APPLICATION NO: A/161/19/DOC

Site Address: Pound Place Roundstone Lane Angmering BN16 4AL

Description of Works: Approval of details reserved by condition imposed under ref A/9/19/PL relating to Condition Nos 3 - proposed surface water drainage and 16 - Construction & Environmental Management Plan.

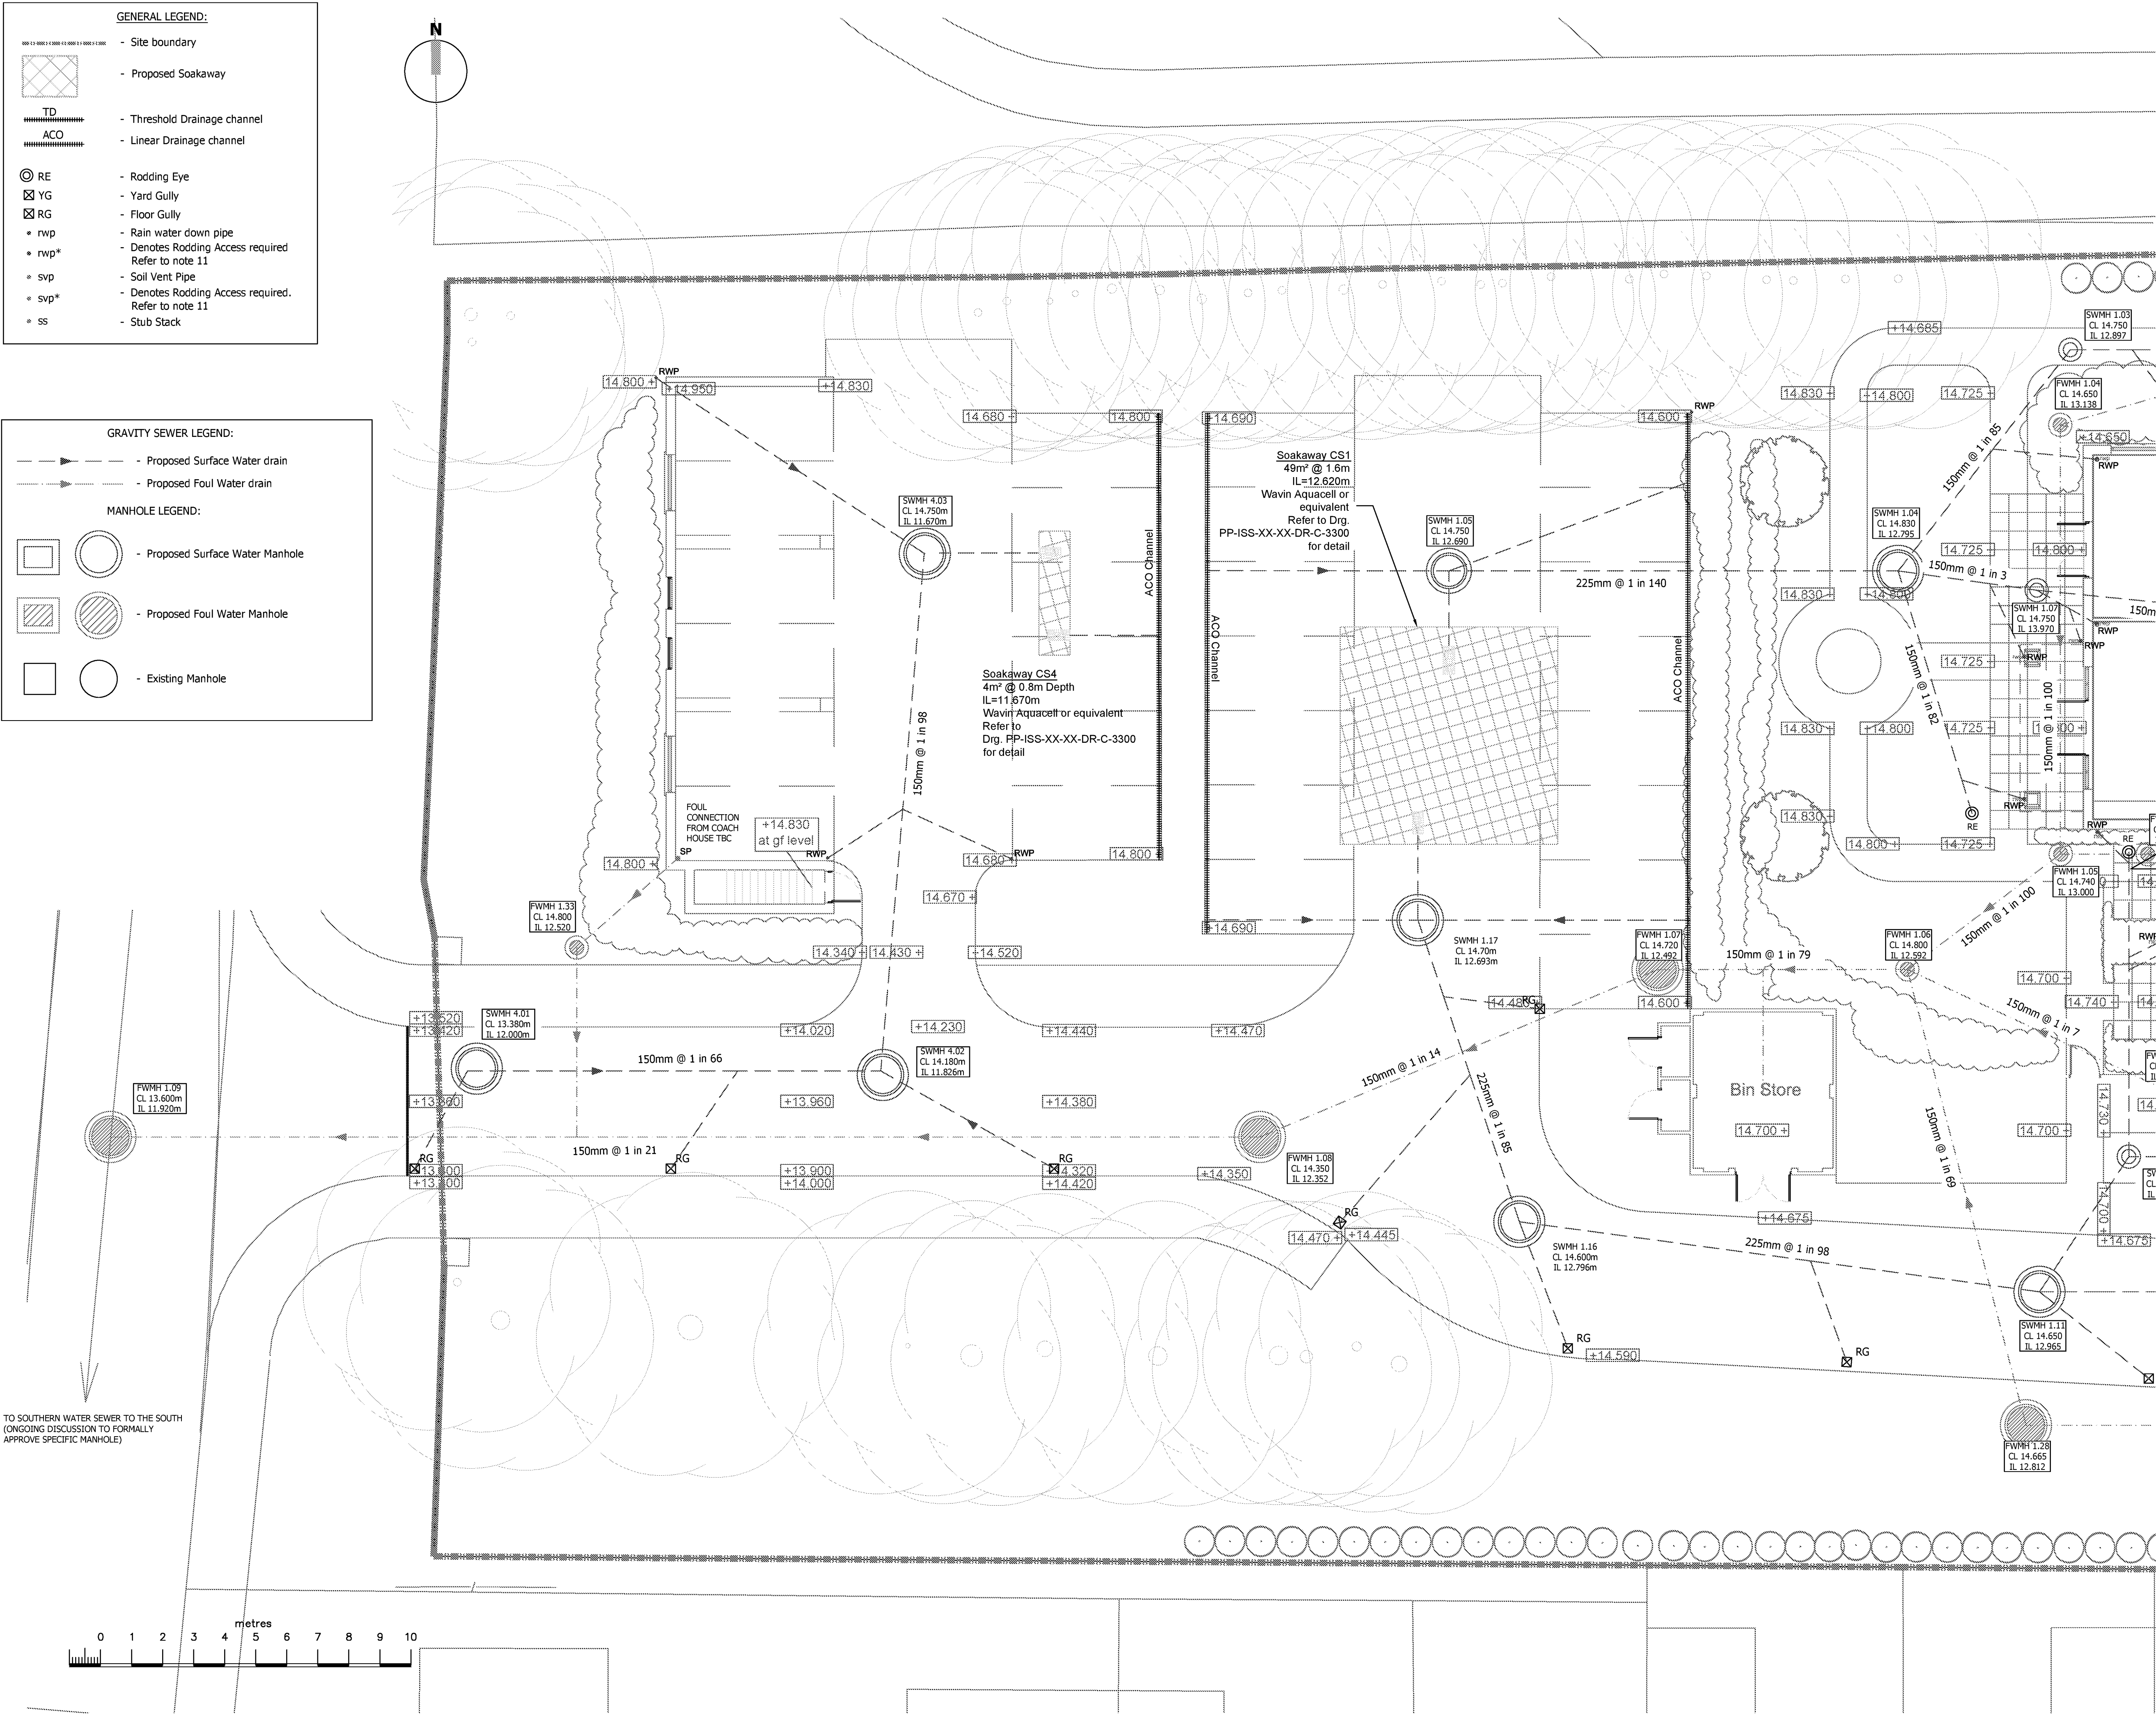
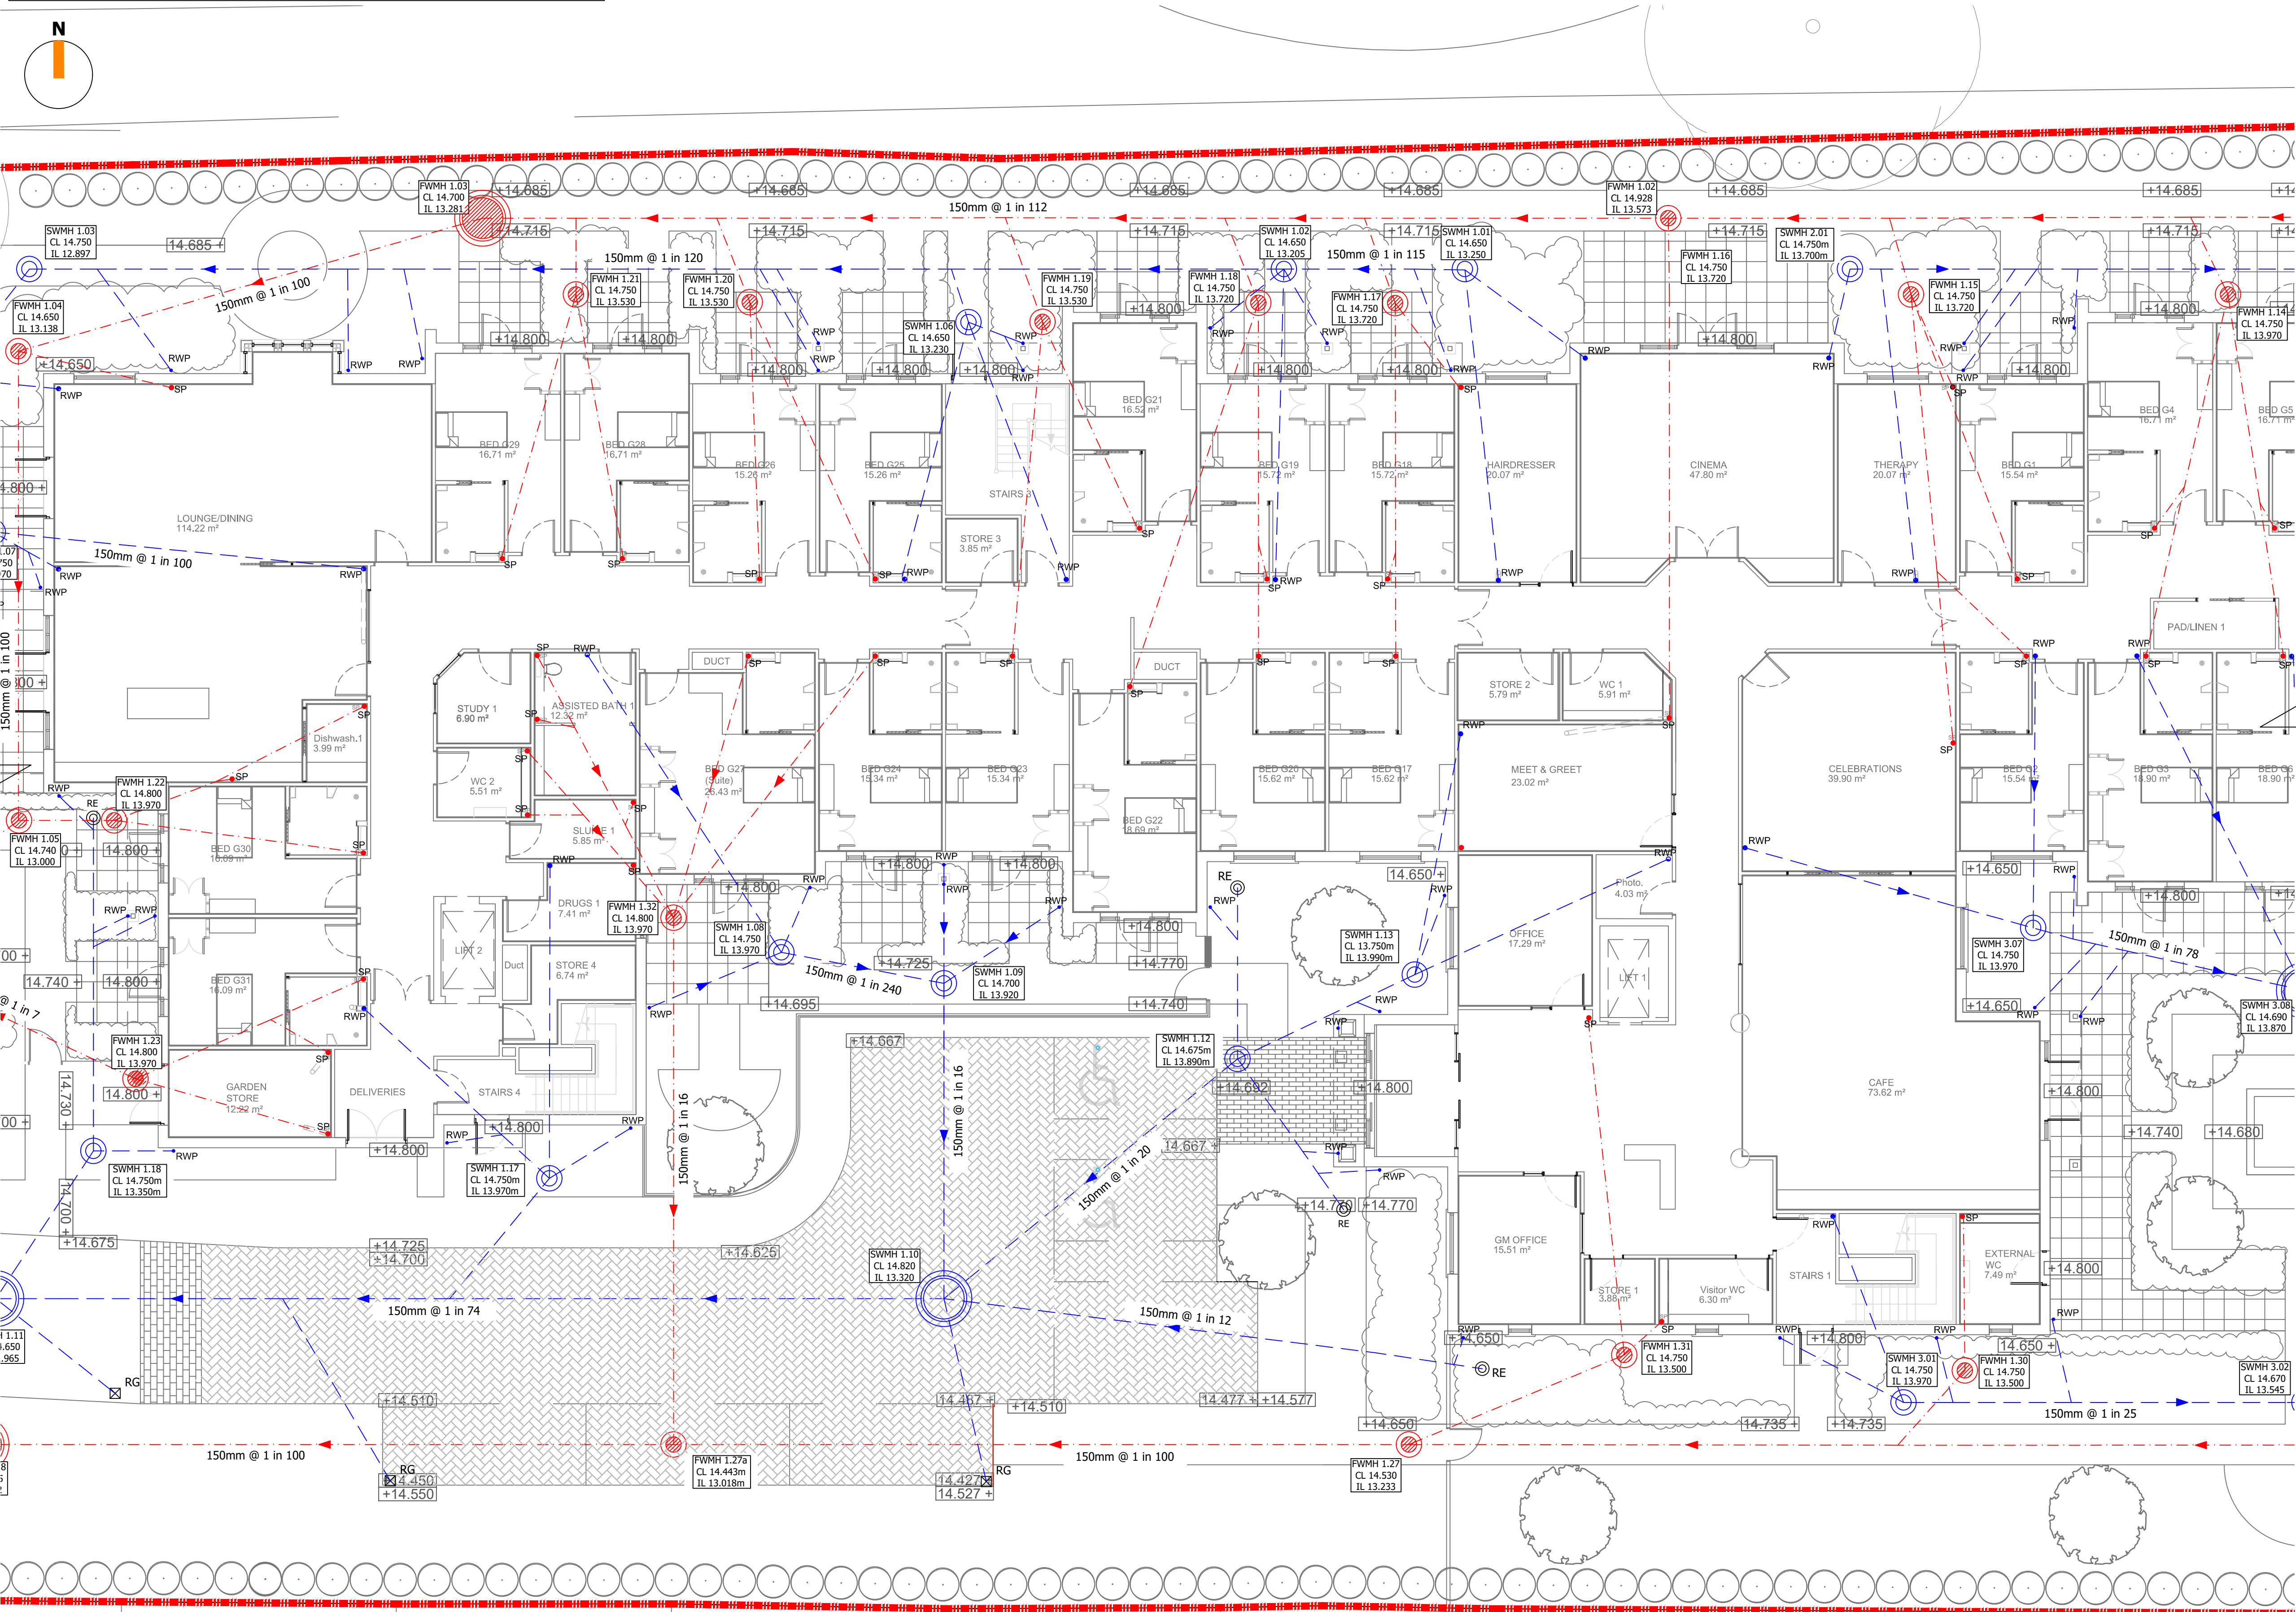
1. The proposed drainage plan in the Drainage Design Calculations differs significantly from the Drainage Layouts supplied. The number and locations of soakaways are different. Please clarify which plan is to be used and remove the other. If the calculations need to be amended for the Drainage Layout drawings please do so.

3. It is unclear as to whether or not permeable paving is to be used. In the Drainage Design Calculations permeable paving is referenced multiple times but this does not seem to be shown on the Drainage Layout drawings, or on the construction details. If permeable paving is to be used please clearly mark it on the layout drawings and include construction details for it. If not please amend the Calculations and provide justification for the change in strategy.
